# TRAFFIC IMPACT ASSESSMENT (TIA)

**Proposed Waste Management facility  
2-4 Hale Street, Botany**

Reference: 23.464r01v13  
Date: March 2025

This revised TIA has been prepared to accompany an amended SSD application to address comments concerning the proposal from Department of Planning, Housing and Infrastructure (DPHI) as contained in a letter dated 13 September 2024 (DPHI Reference: SSD-62855708), and Bayside Council as contained in a letter dated 9 September 2024 (Council Reference: SSD-2024/10).

Project No.	Drawing Phase	Drawing No.	Rev.
23.464	RFI	TX.07	A

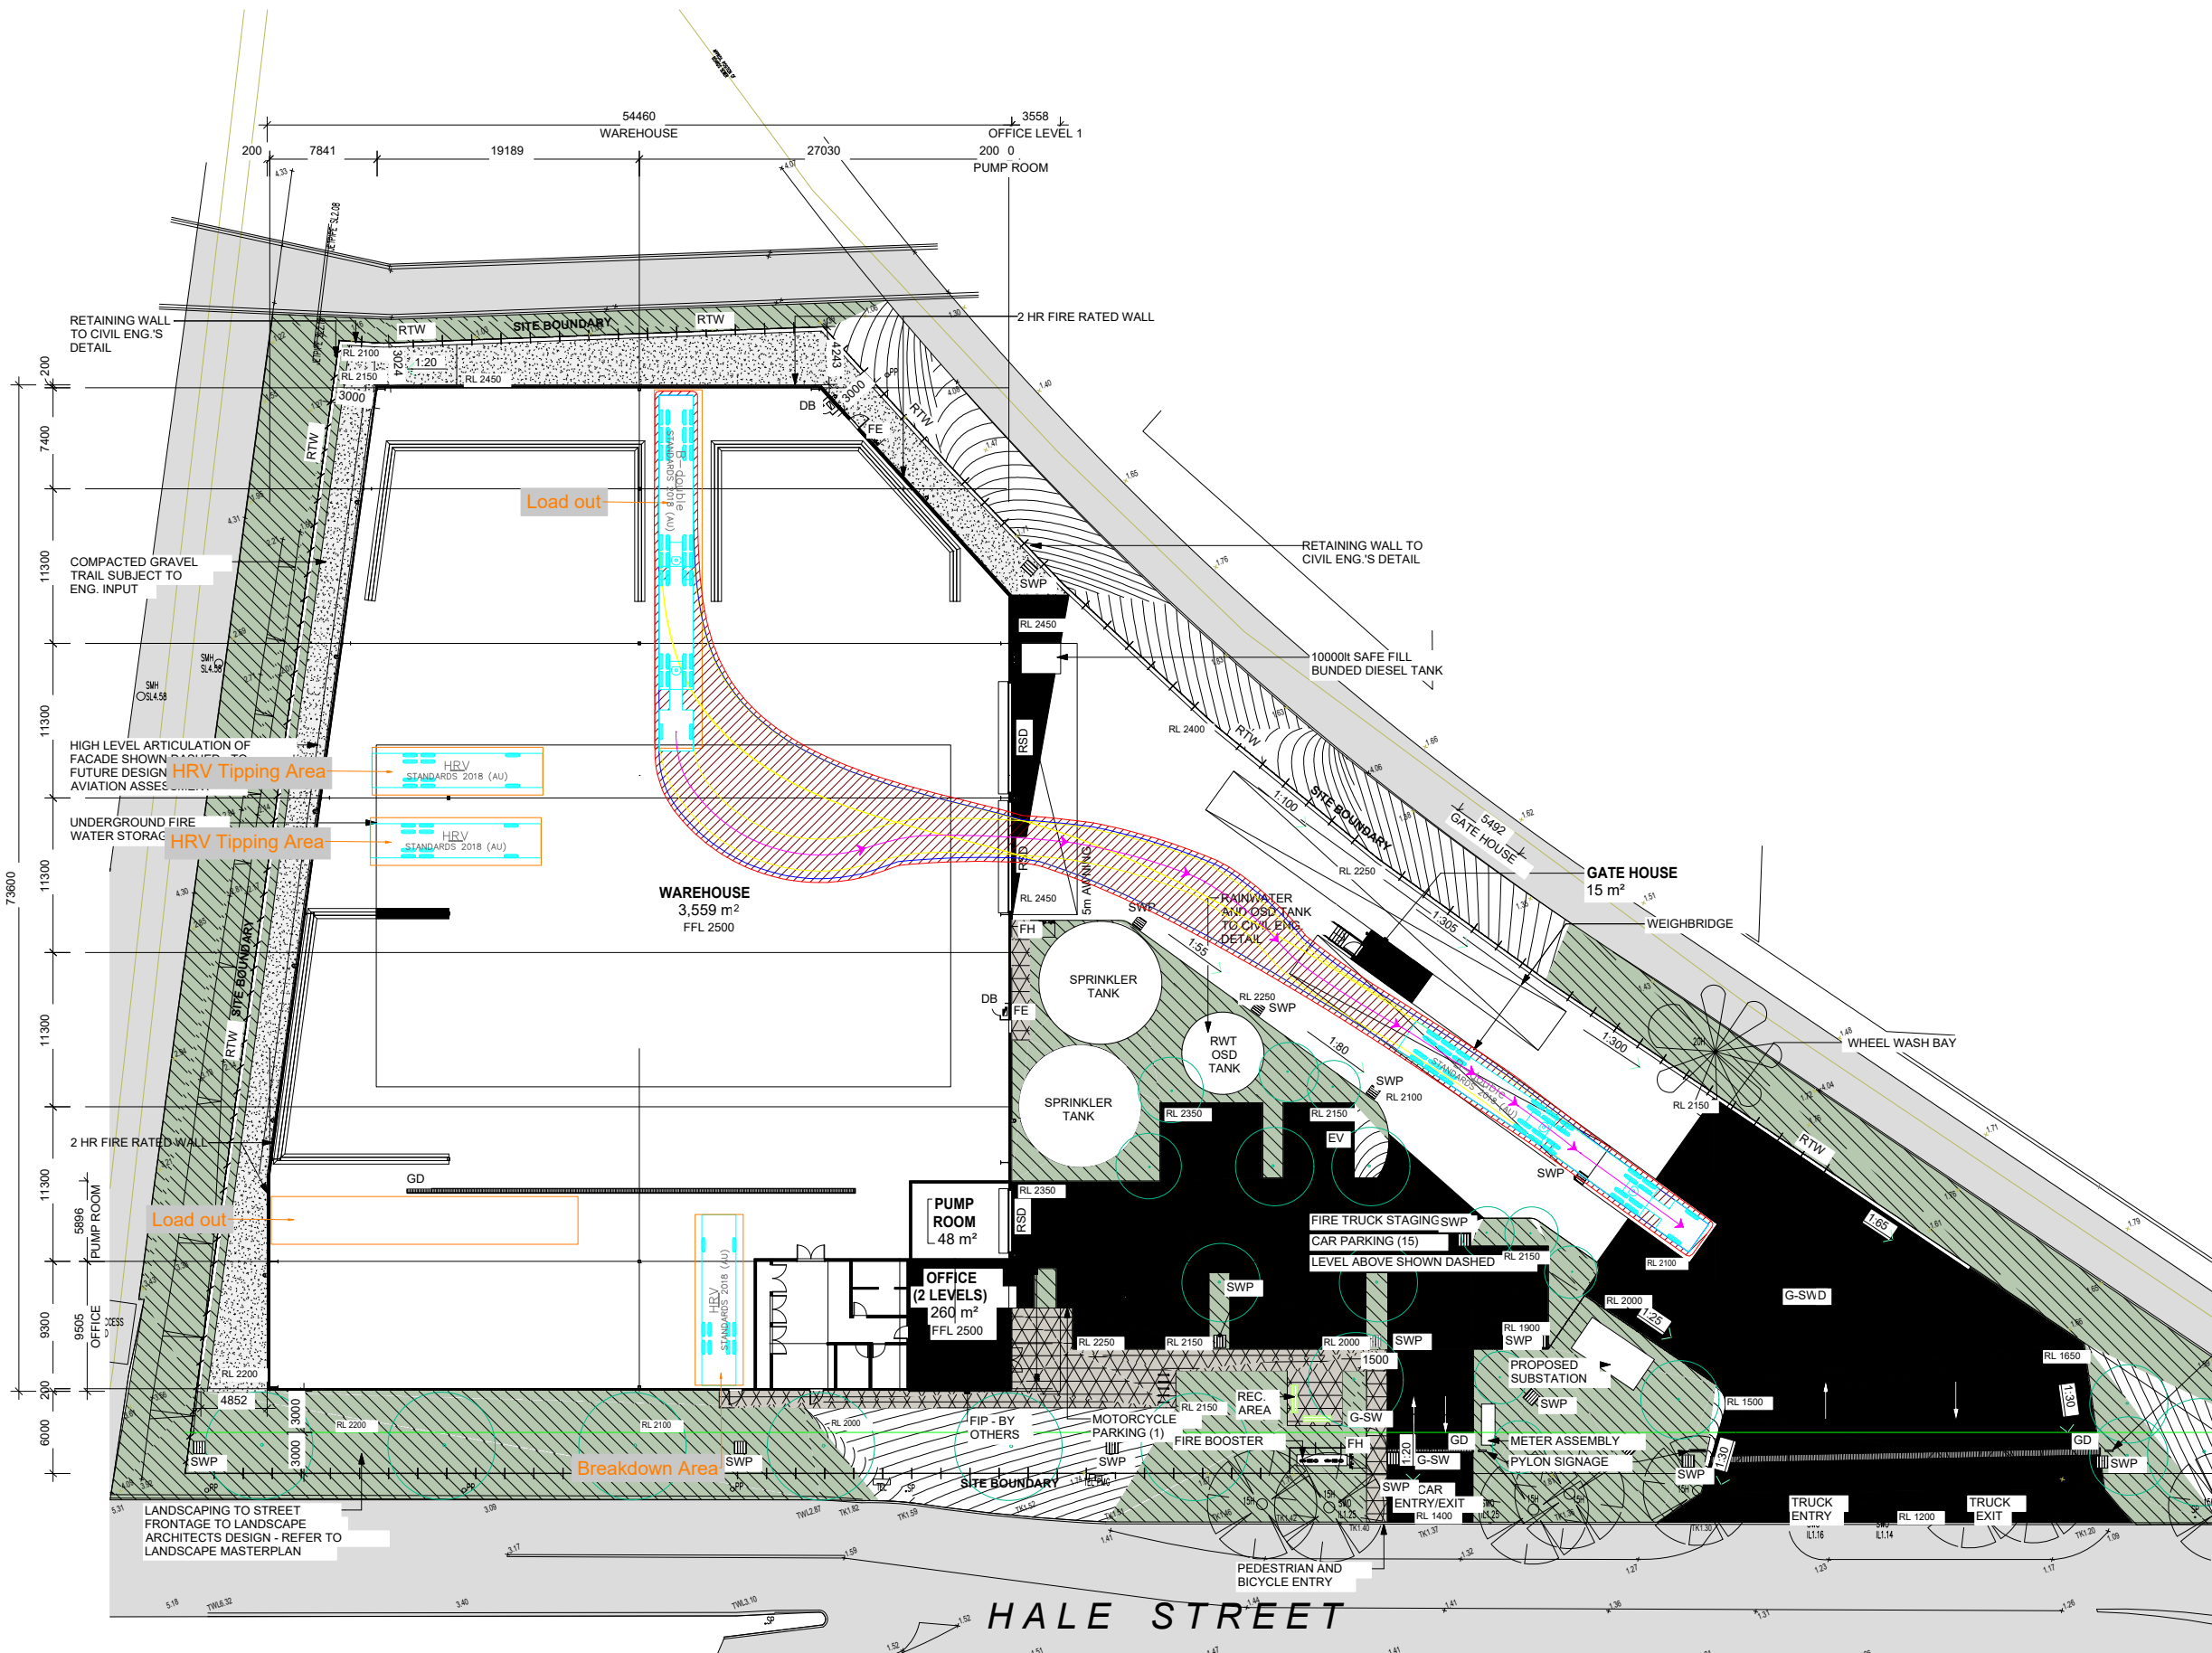
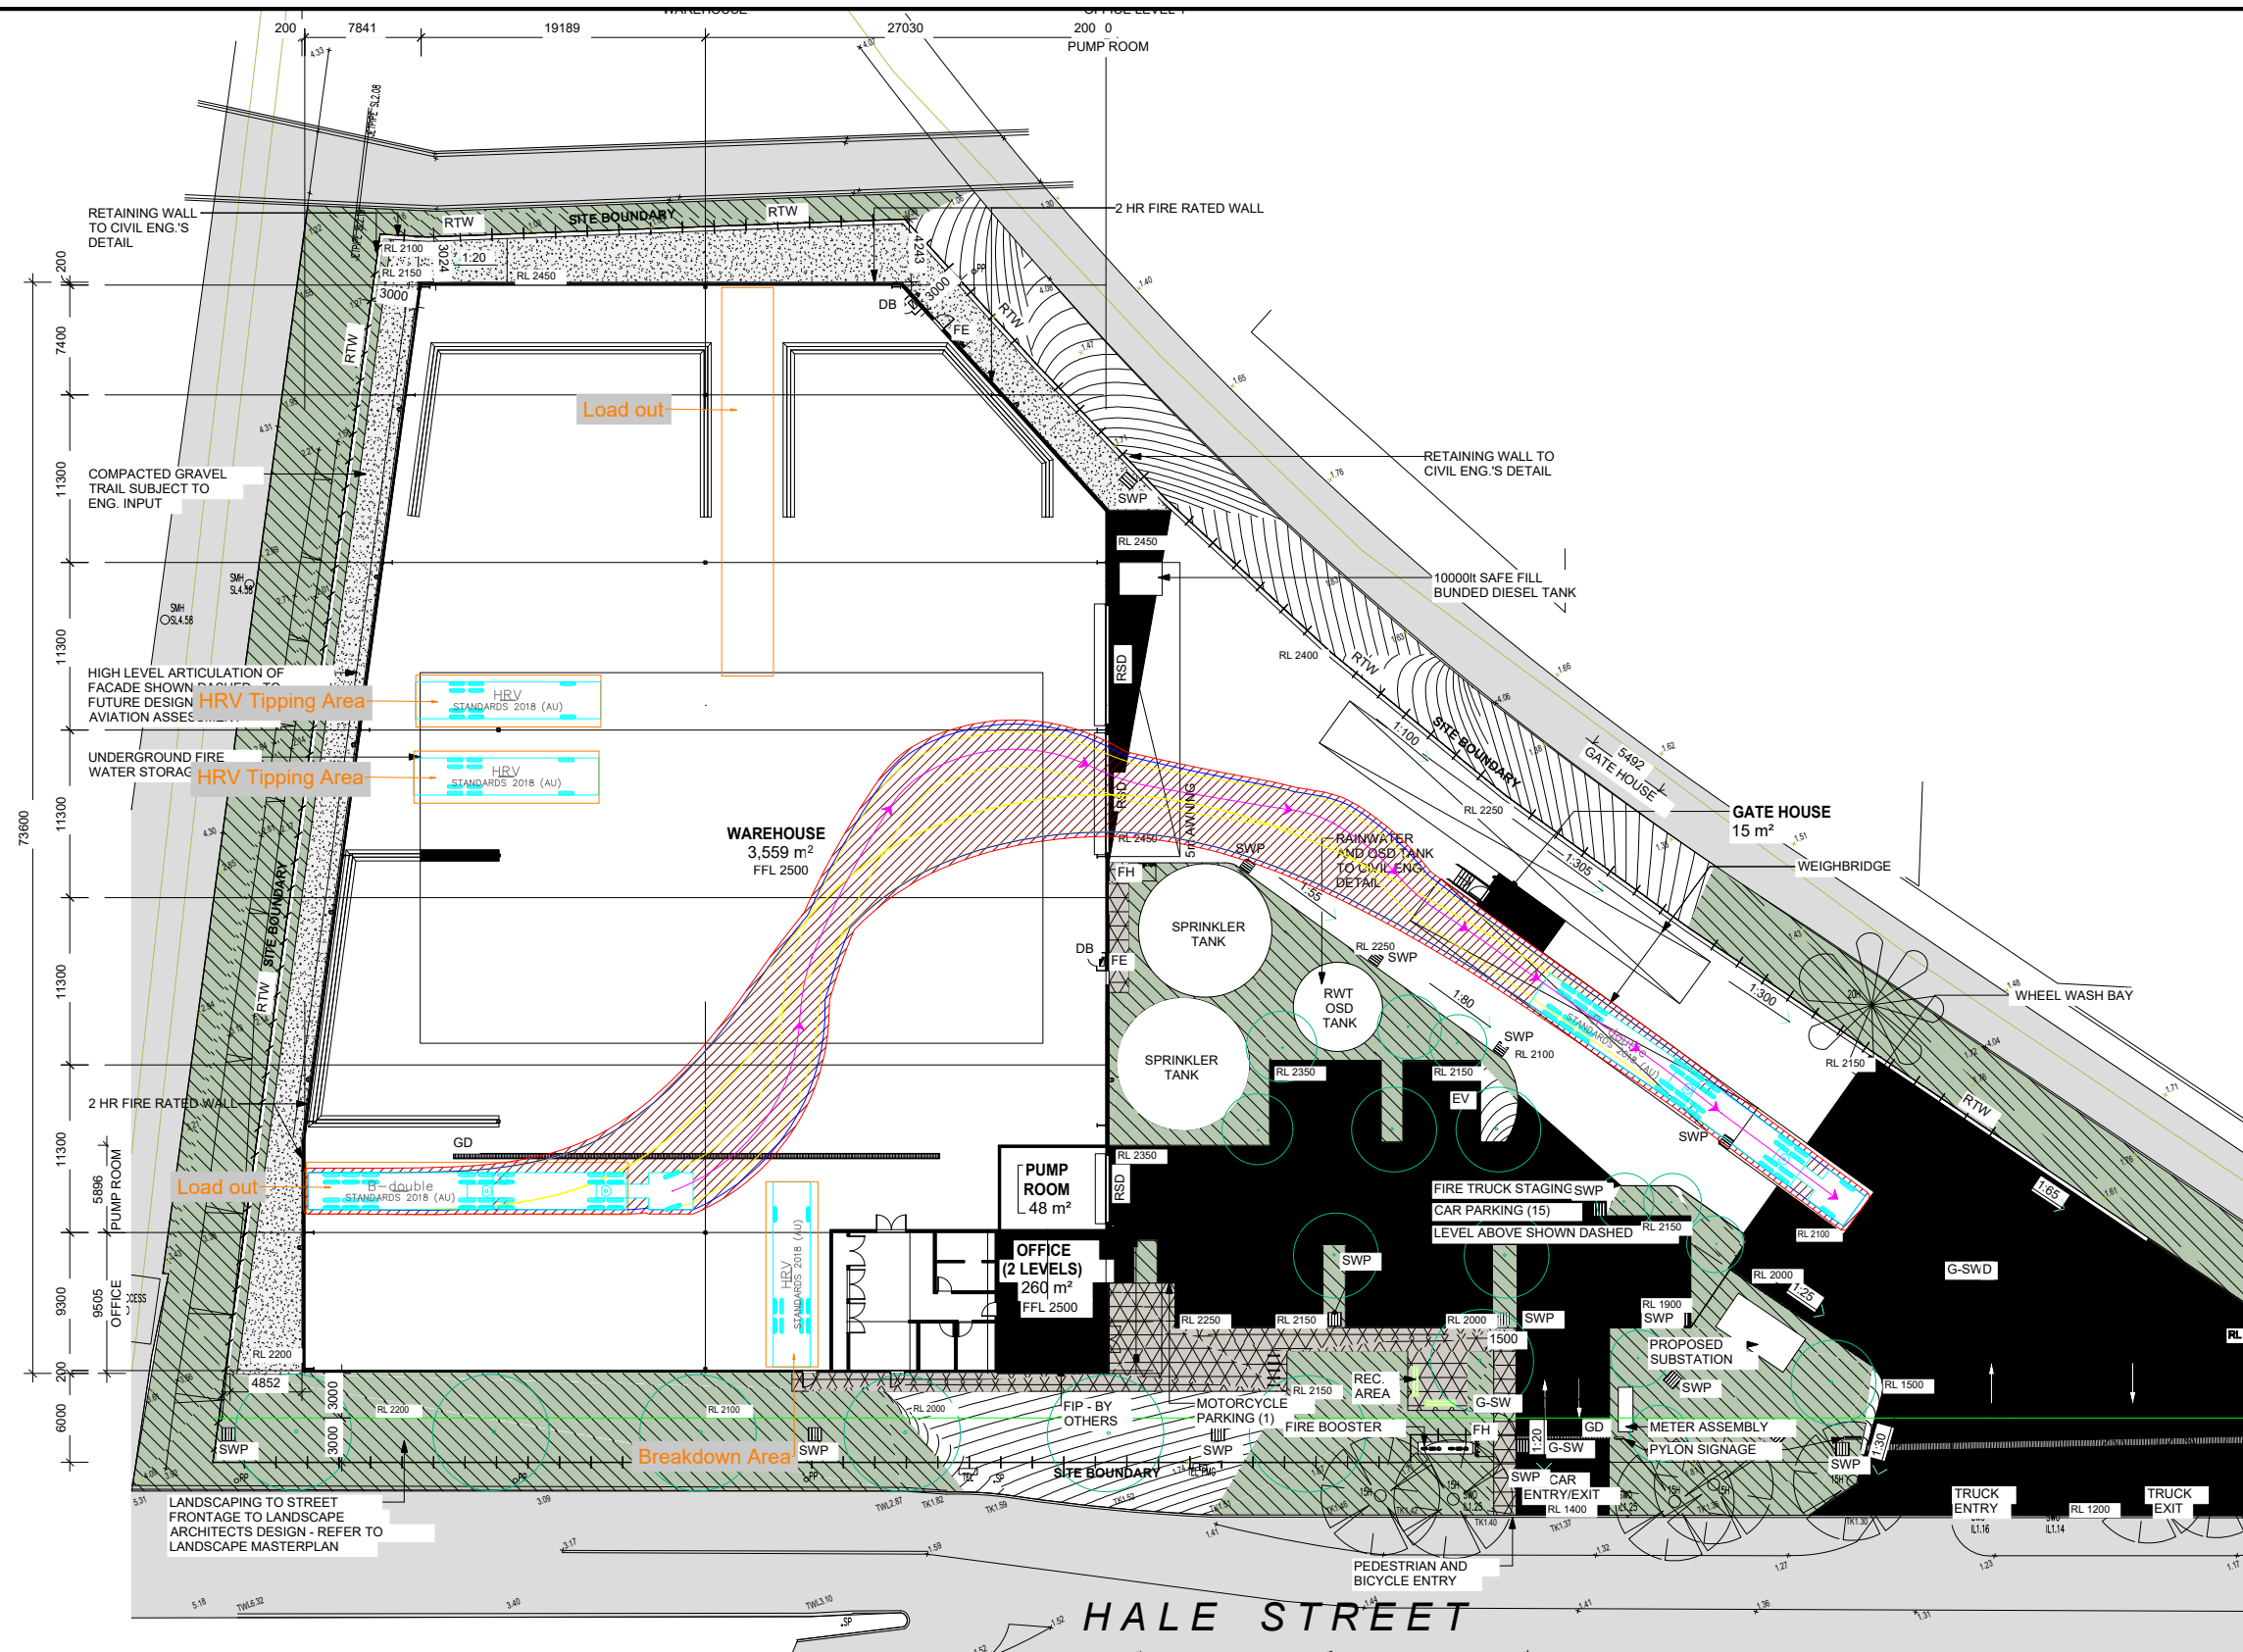
<p><b><u>Swept Path Analysis</u></b></p> <p>The swept path analysis for the site access driveway provided at Appendix D of the TIA is unclear and indicates there may be conflict between two B-doubles travelling eastbound and westbound on Hale Street.</p> <p><b>Recommendation: Revised swept path analyses are required for 20 metre articulated vehicles and B-doubles accessing the site that clearly demonstrates the centreline of Hale Street will not be crossed and there will be no conflict with on-street parking. All line marking on Hale Street must be clearly marked.</b></p>	<ul style="list-style-type: none"> <li>• Swept path analysis have been updated with recent Nearmap aerial georeferenced in the background clearly demonstrating 26m B-double vehicles will be able to ingress and egress the site satisfactorily in accordance with AS 2890.2 (2018).</li> </ul>
<p><b><u>Daily Heavy Vehicle (HV) Movements</u></b></p> <p>Section 6.10: Truck Frequencies of the TIA outlines the anticipated truck volumes for the development. It is not clear how these vehicle numbers have been determined. Bayside Council has also raised several queries regarding the traffic generation analysis.</p> <p><b>Recommendation: Additional information is required to justify the predicted truck volumes, including the breakdown of vehicle types.</b></p>	<ul style="list-style-type: none"> <li>• TIA has been updated to provide detailed calculations on how the anticipated heavy vehicle trip generation associated with the proposed development has been estimated including a breakdown of the vehicle types, refer to <b>Section 9</b>.</li> </ul>

<p>The appendix D swept path analysis details an unrealistic kink in the truck wheel movement near the car entry/exit. See figure below.</p>	<ul style="list-style-type: none"> <li>All swept path analysis has been undertaken using the latest version of the industry leading software AutoTURN Pro, we can provide animated swept paths in a video file or live demonstration to Council upon request to prove our professional integrity.</li> </ul>
<p>The swept path analysis shall be revised to better depict all line marking on Hale Street. Vehicles shall not cross over the road centreline.</p>	<ul style="list-style-type: none"> <li>Swept path analysis have been updated with recent Nearmap aerial georeferenced in the background clearly demonstrating 26m B-double vehicles will be able to ingress and egress the site satisfactorily in accordance with AS 2890.2 (2018).</li> </ul>
<p>The parking rate derived in section 7 of the traffic report is insufficient for this site. 1 car parking space shall be provided for each staff member in addition to the 4 visitor spaces. Additionally, given the swept paths and the two driveways proposed, the on- street parking on the northern side of Hale Street is effectively entirely removed by this development. The loss of public parking needs to be supplemented by the development.</p>	<ul style="list-style-type: none"> <li>The proposed development has been amended to provide a minimum of one (1) car parking space per FTE staff in addition to the four (4) visitor spaces in accordance with Council's request.</li> <li>It is unclear how on-street parking can be supplemented by a private development that is not open to the public notwithstanding the security and legal challenges if this was permitted to occur.</li> <li>Refer to <b>Section 8.6</b> of this report.</li> </ul>
